## DECISION DELEGATED TO HEAD OF PLANNING

**Application No:** H09-1130-21      **Applicant:** Mr J Bingham  
**Proposal:** Proposed bungalow and detached garage  
**Location:** Plot Rear Of 2 Cranmore Lane Holbeach Spalding  
**Terminal Date:** 31st December 2021

PROPOSED ELEVATIONS

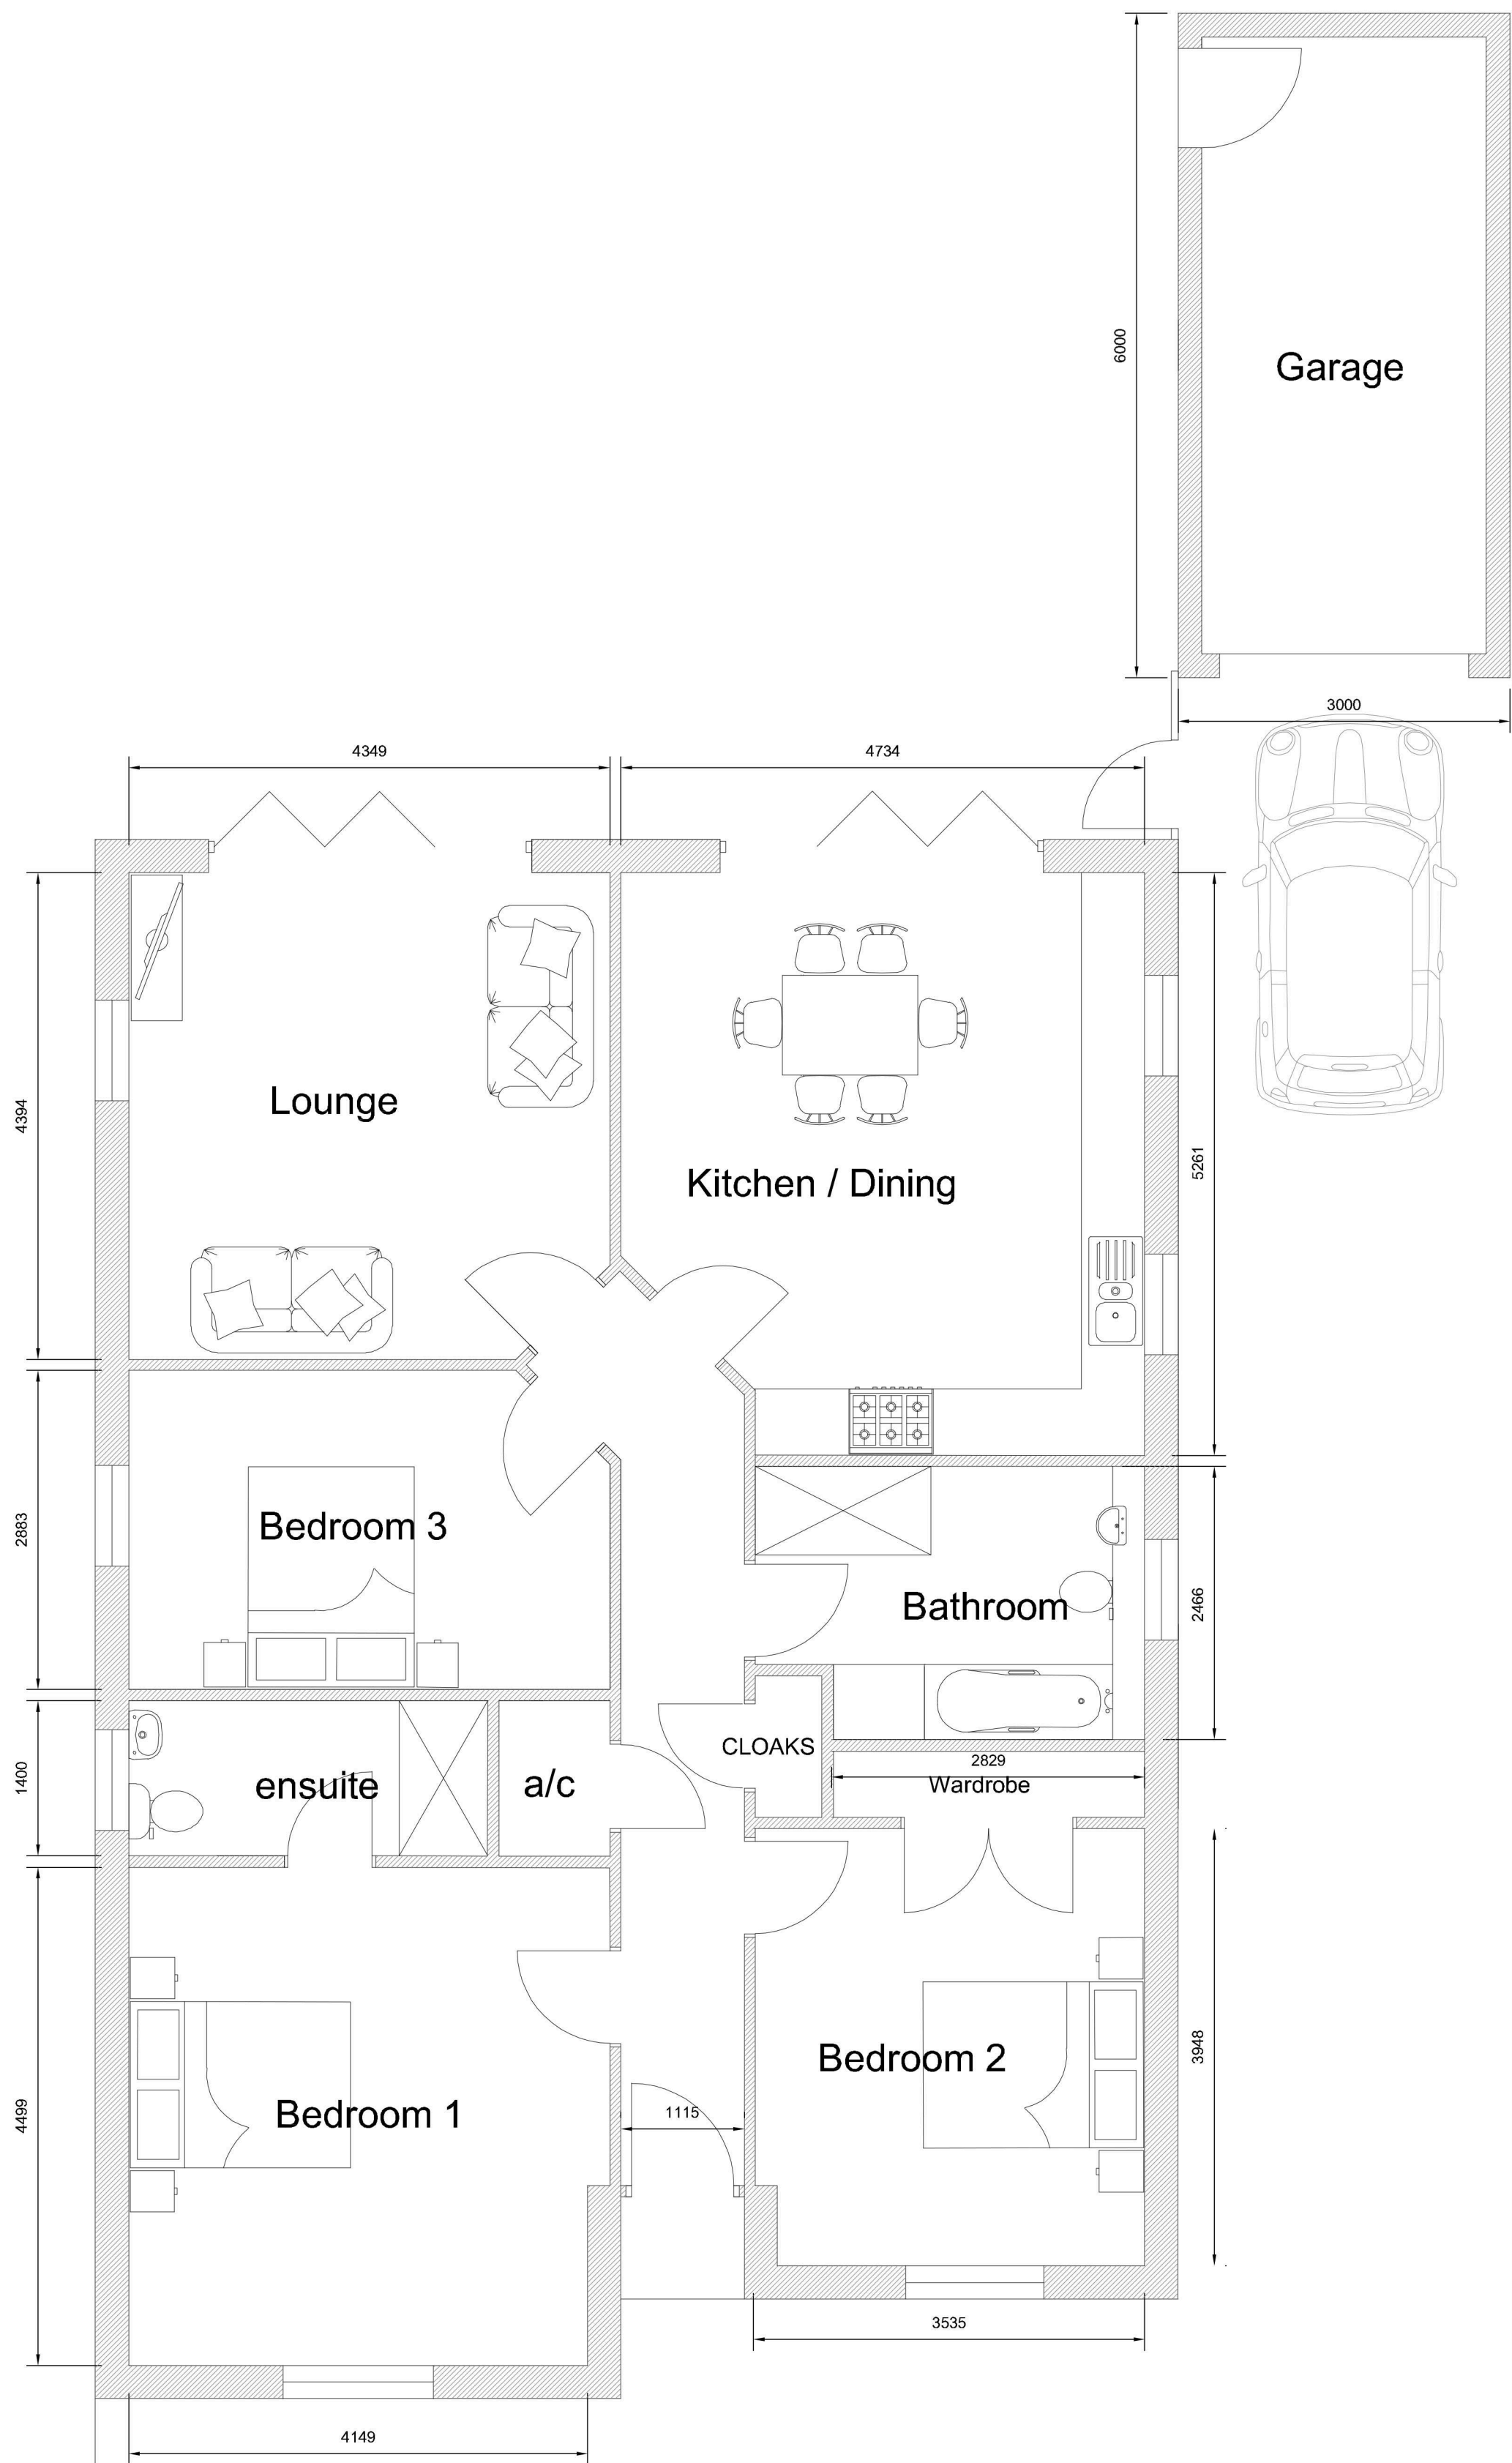
The closest dwelling to the proposed development would be no.4 Cranmore Lane. This neighbour has objected to the proposal on grounds of overlooking and loss of privacy from the proposed windows in the side elevation of the new bungalow facing this neighbour. The concerns are noted, however, it is not considered that the development would result in any unacceptable overlooking or loss of privacy given the proposed dwelling would be single storey and the windows would not offer any significant views above the boundary fence.

PROPOSED BLOCK PLAN

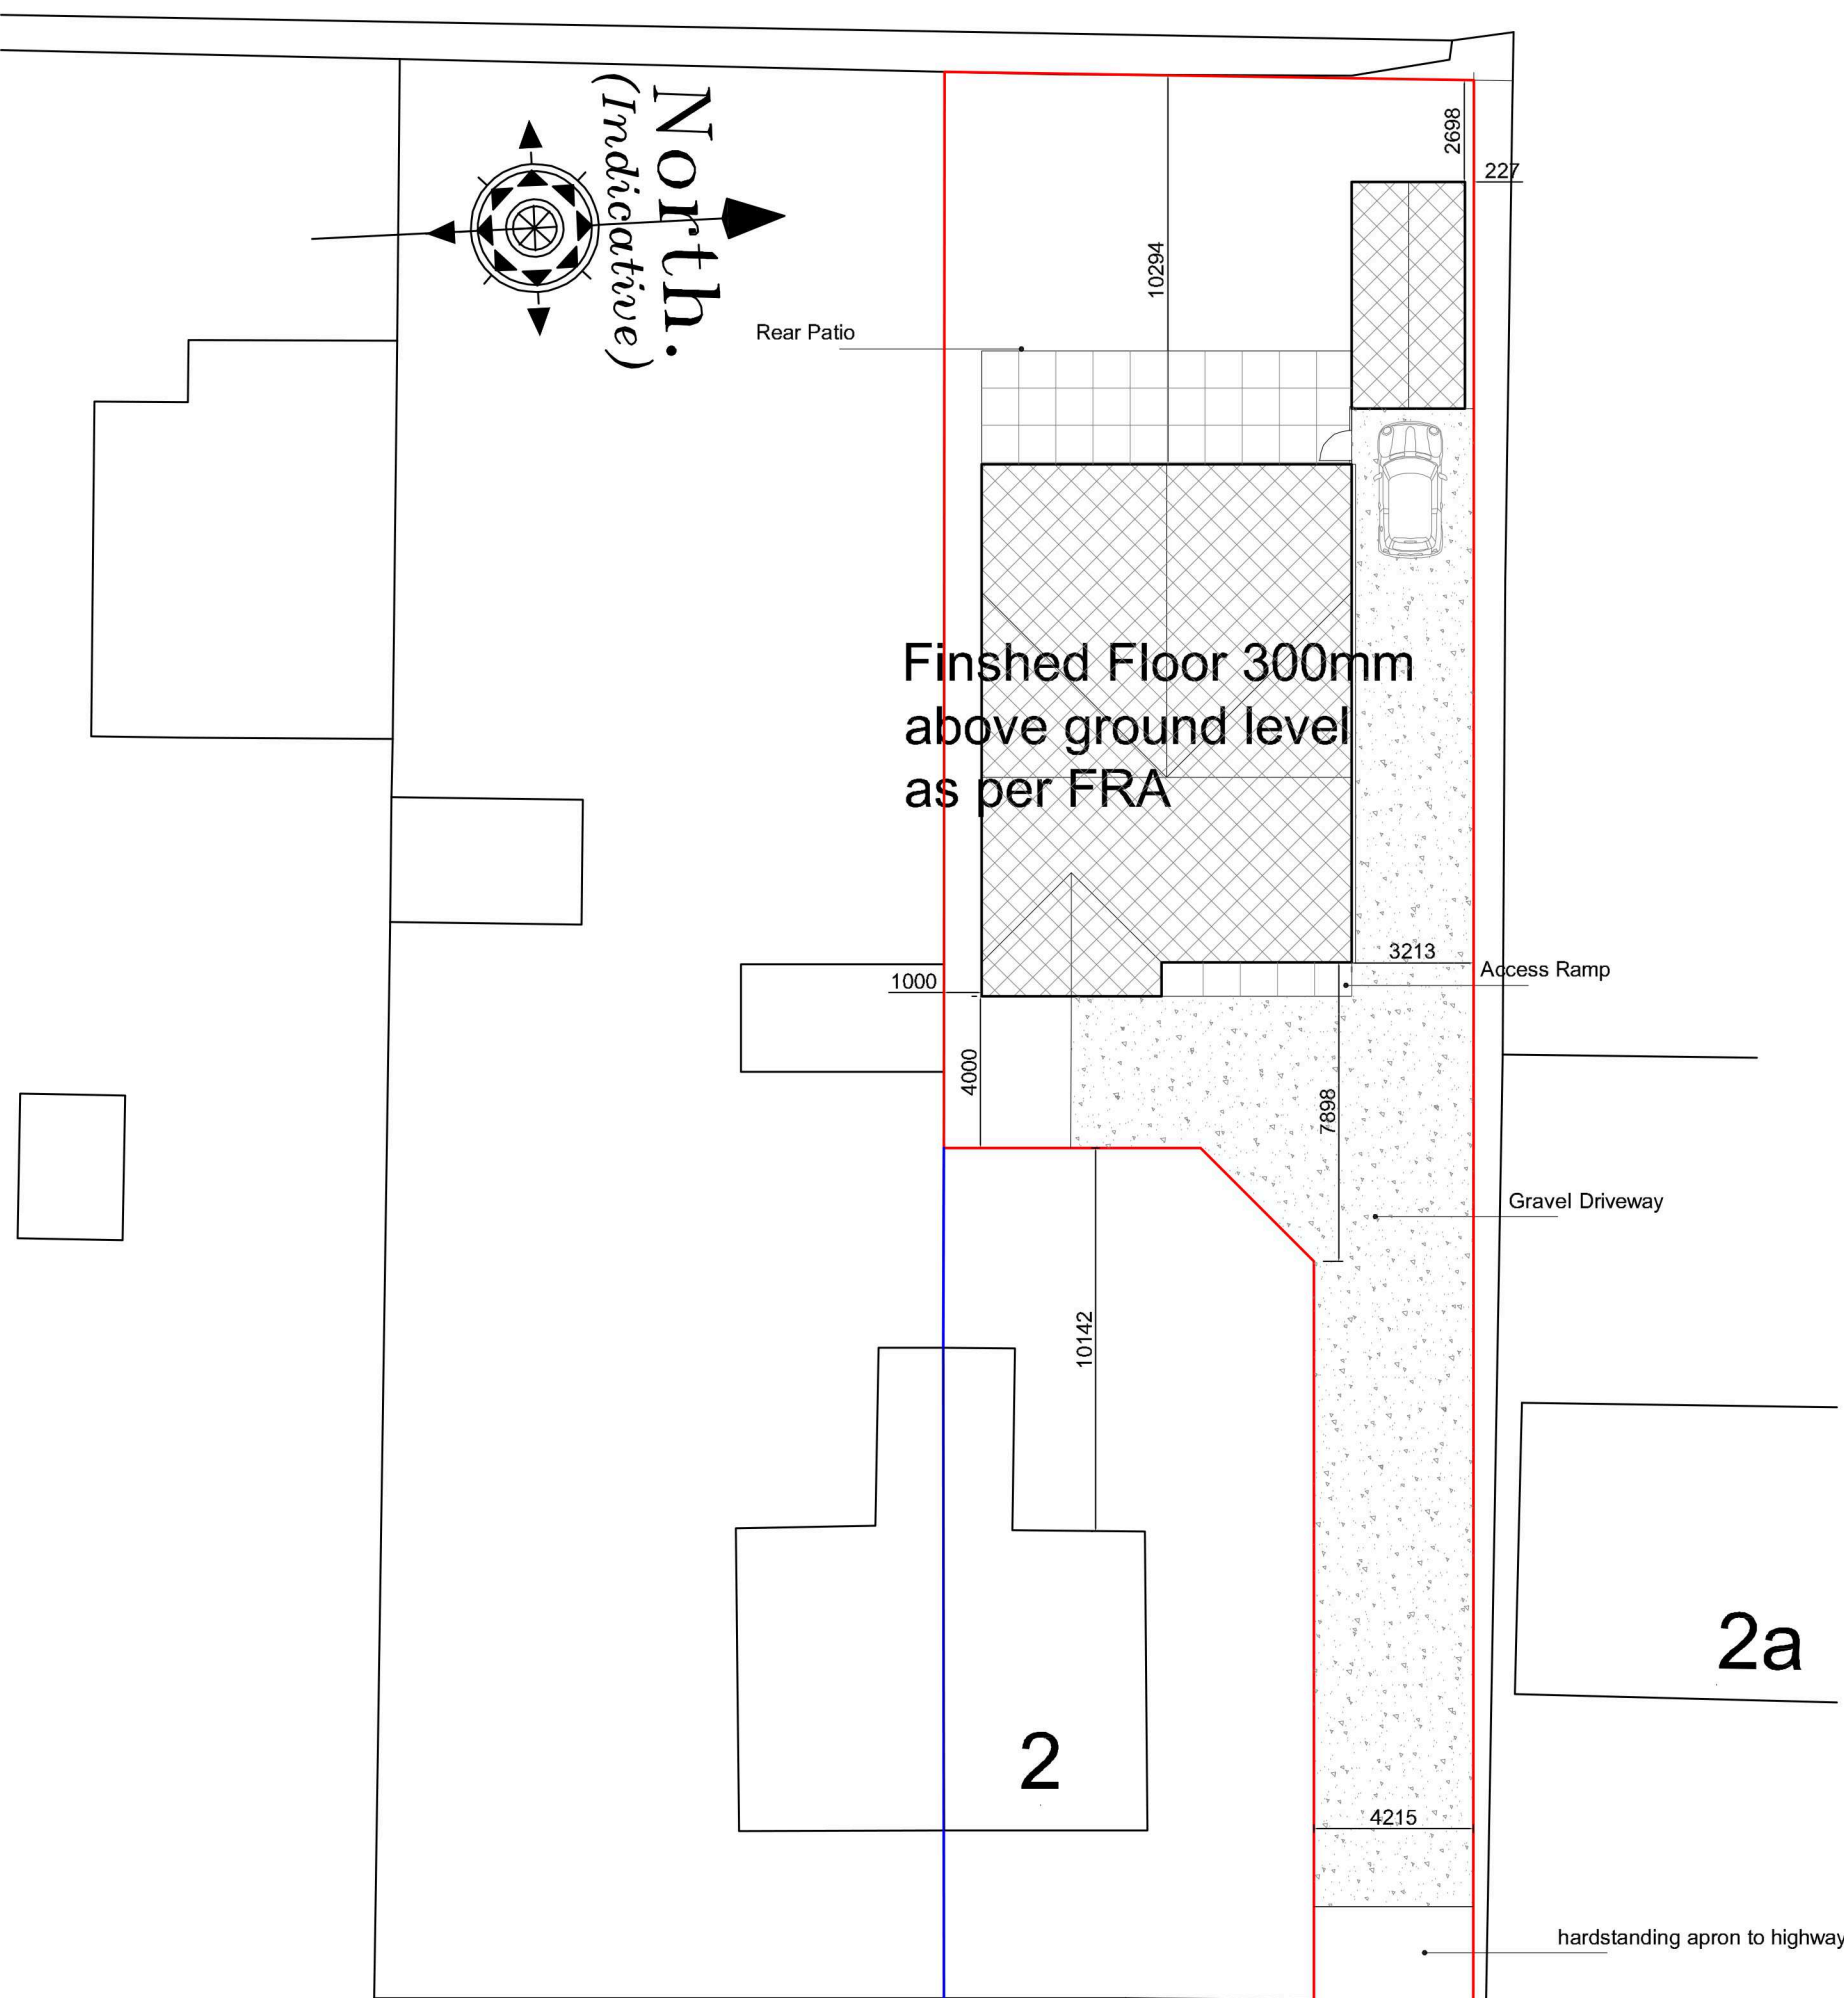
Existing residential development along this section of Cranmore Lane is predominantly facing the street. The proposal would go against the current built form and result in backland development. Furthermore the proposed subdivision of the site would result in an inappropriate and cramped appearance and overdevelopment of the site with little outdoor amenity space afforded to the existing and proposed dwellings.

With regards to the neighbour to the north, the proposed dwelling would be located approximately 3.2 metres from the shared boundaries and would sit adjacent to the rear gardens of these neighbours. Given the proposed driveway would extend almost the entire depth of the site the amenity of neighbouring residents would be materially harmed by virtue of noise and disturbance from future occupiers of the proposed bungalow using the private drive. In addition, given the close proximity of the proposed structure to the northern boundary some overshadowing is also likely to result on no's 83 and 85 Hall Gate.

The current parking provision for the existing dwelling would be lost and no new parking is indicated on the submitted plans. However, it is considered that sufficient parking could be achieved for the existing dwelling to the front/side of the dwelling. As such minimum parking standards could be ensured.
